141386B – Land to the north east of King George V Playing Fields, Cuffley Transport Technical Note

141386B/N02

1. Vectos has been appointed by Lands Improvement to provide traffic and transport advice in support of a planning application for a residential development of up to 121 dwellings, associated infrastructure on the land to the north east of King George V Playing Fields, Hertfordshire.

3. Following submission of this update, highways comments were received in email form from Hertfordshire County Council (HCC), which are attached at **Appendix A**.

DRAWING NUMBER:	141386/A/56	REVISION:	A
-----------------	-------------	-----------	---

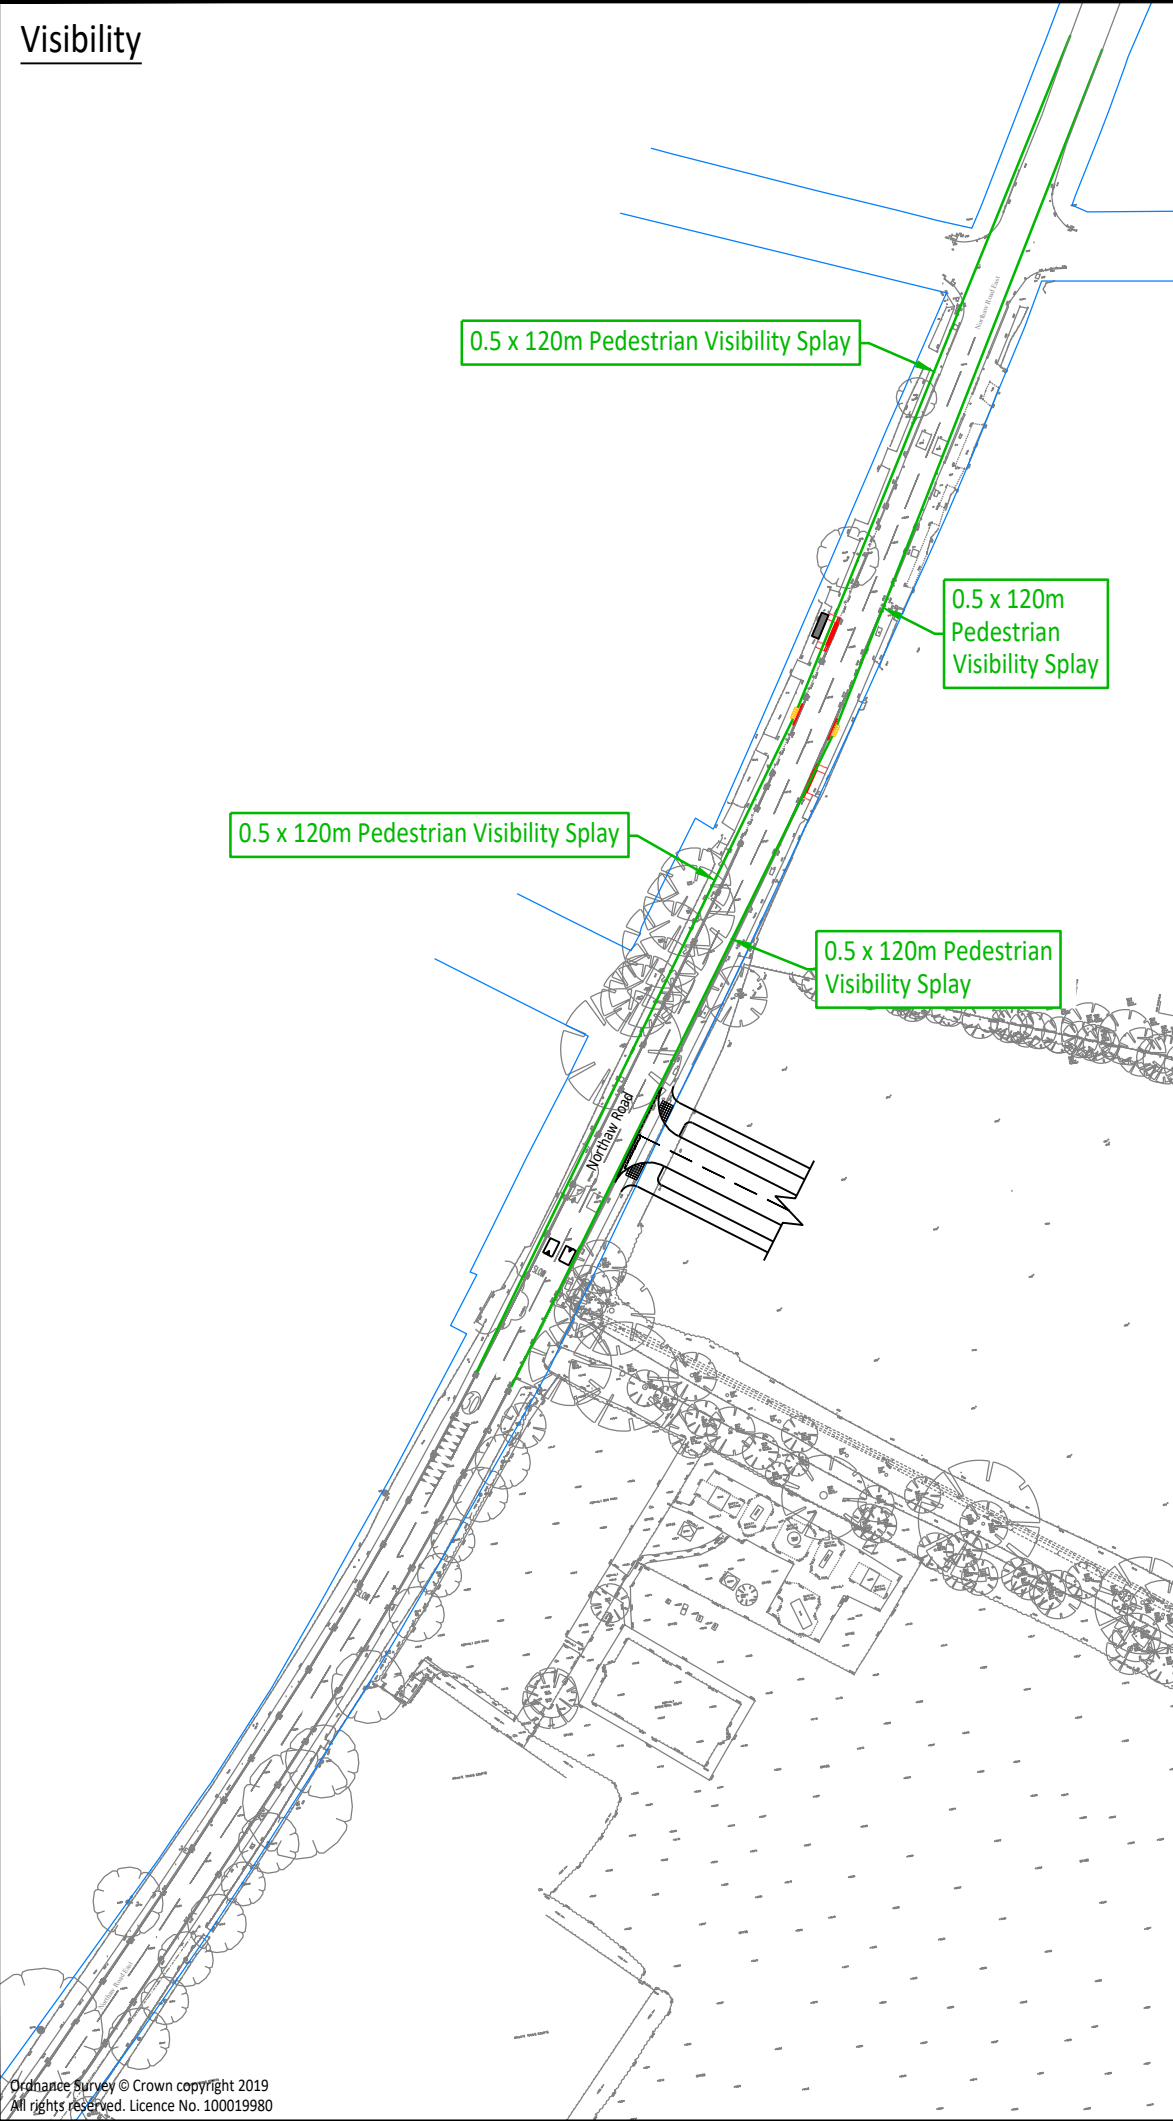
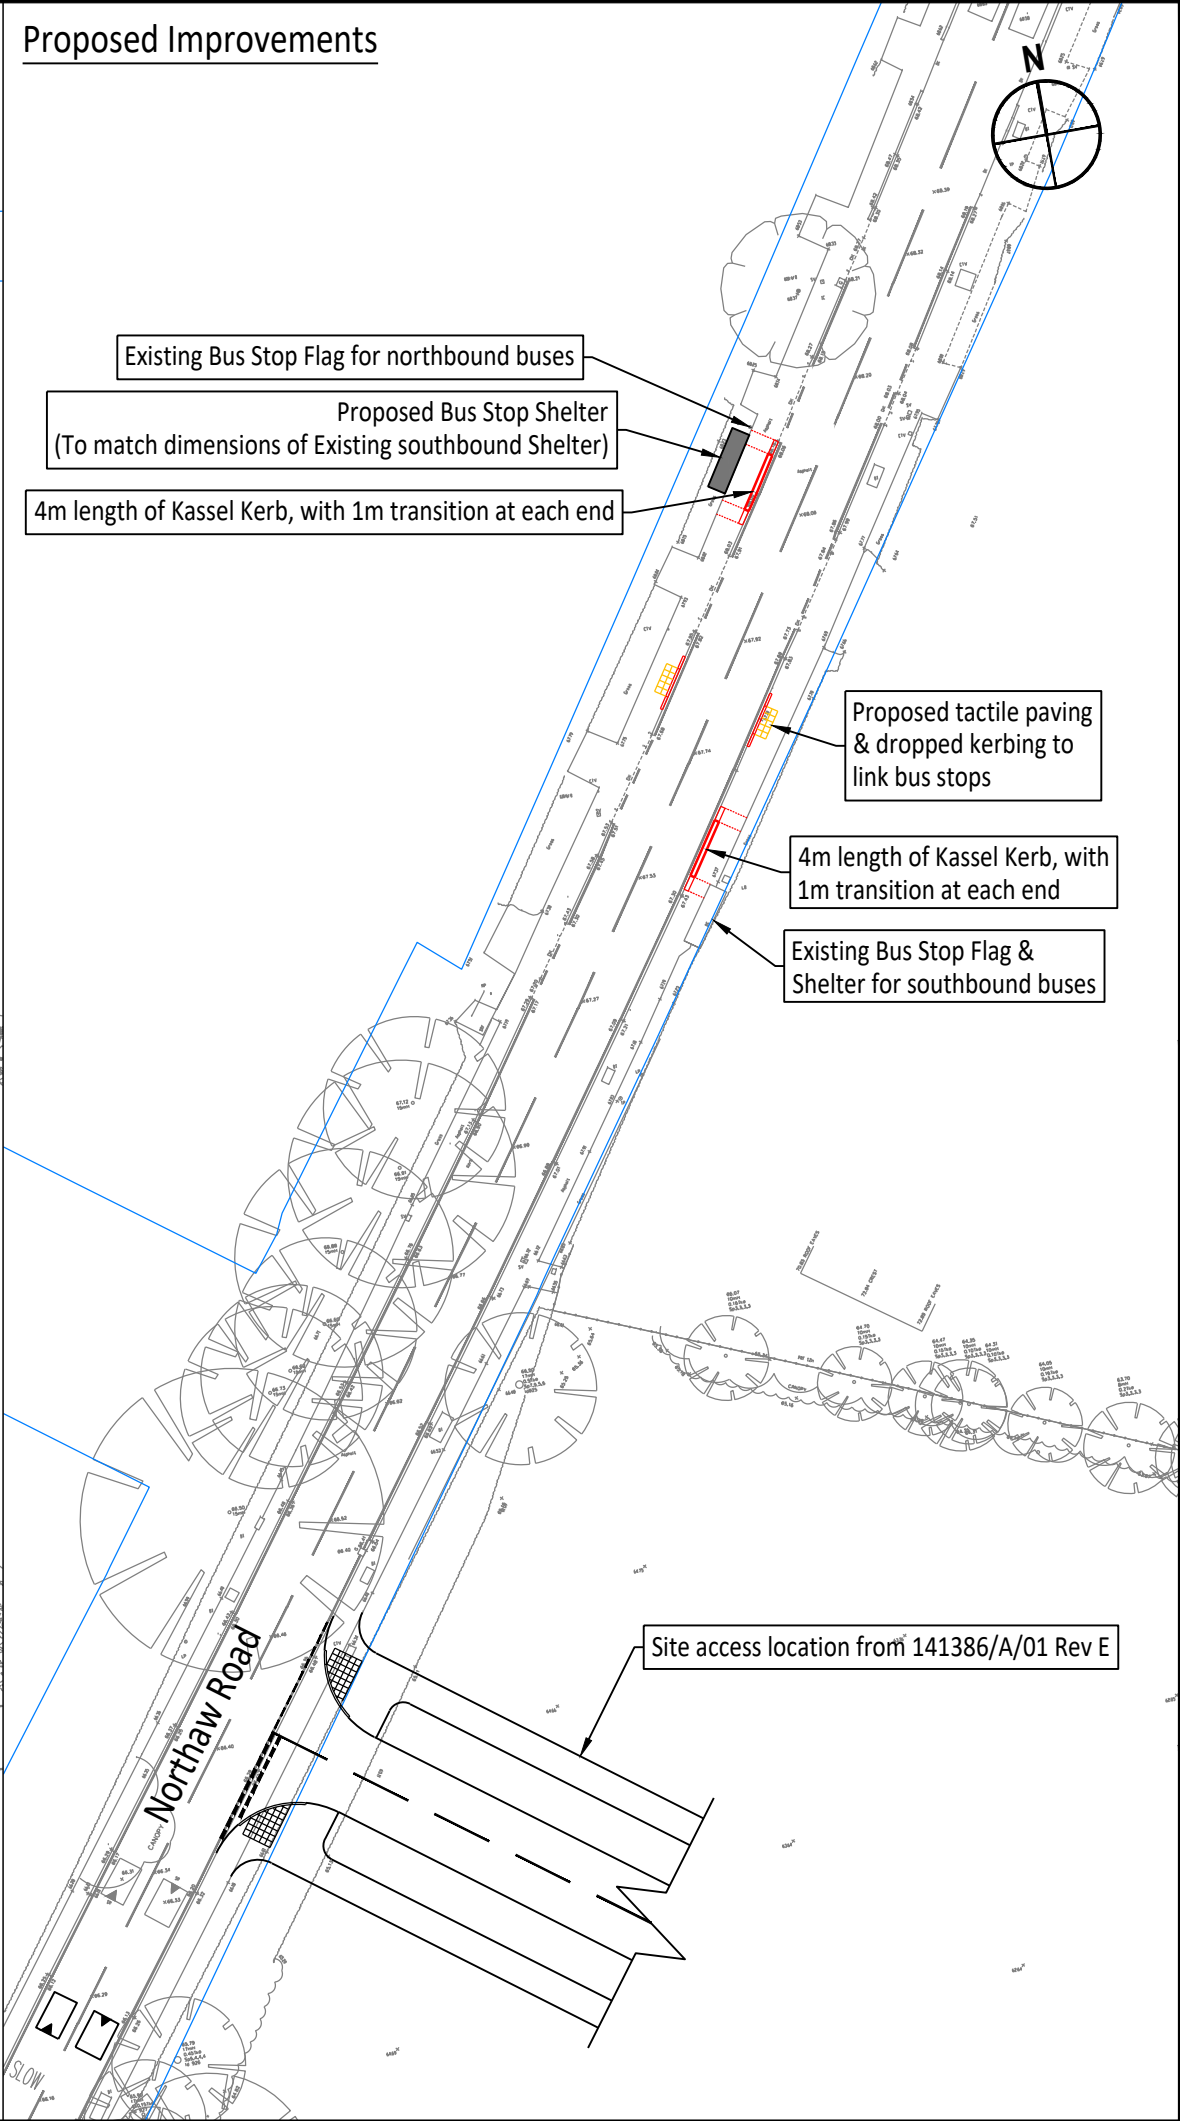
Another first strand scheme is to upgrade the two closest bus stops along Northaw Road. The northbound stop needs a shelter and raised Kassel kerbing added. The southbound stop already has a shelter but no raised Kassel kerbing. I think we also need to see a simple pedestrian dropped kerb / tactile paving crossing point between these two stops to facilitate pedestrian movements accessing them.

23. A review of the bus stop locations along Northaw Road has taken place with the proposed alternative location shown in **Drawing 141386/A/56** contained within **Appendix G**. Due to the existing location of the northbound bus stop, it has been moved southwards so that the Kassel Kerbing can be introduced. Tactile paving and dropped kerbs in order to facilitate crossing Northaw Road have also been introduced. It is proposed to provide these shelters prior to occupation of the first 25 units.
24. A further detailed on-site investigation will be necessary to finalise these proposals if desired
I previously sent you our Travel Plan team's assessment of the TP. Some changes to this are needed.
25. These changes have been made and the updated Travel Plan is attached at **Appendix H**.
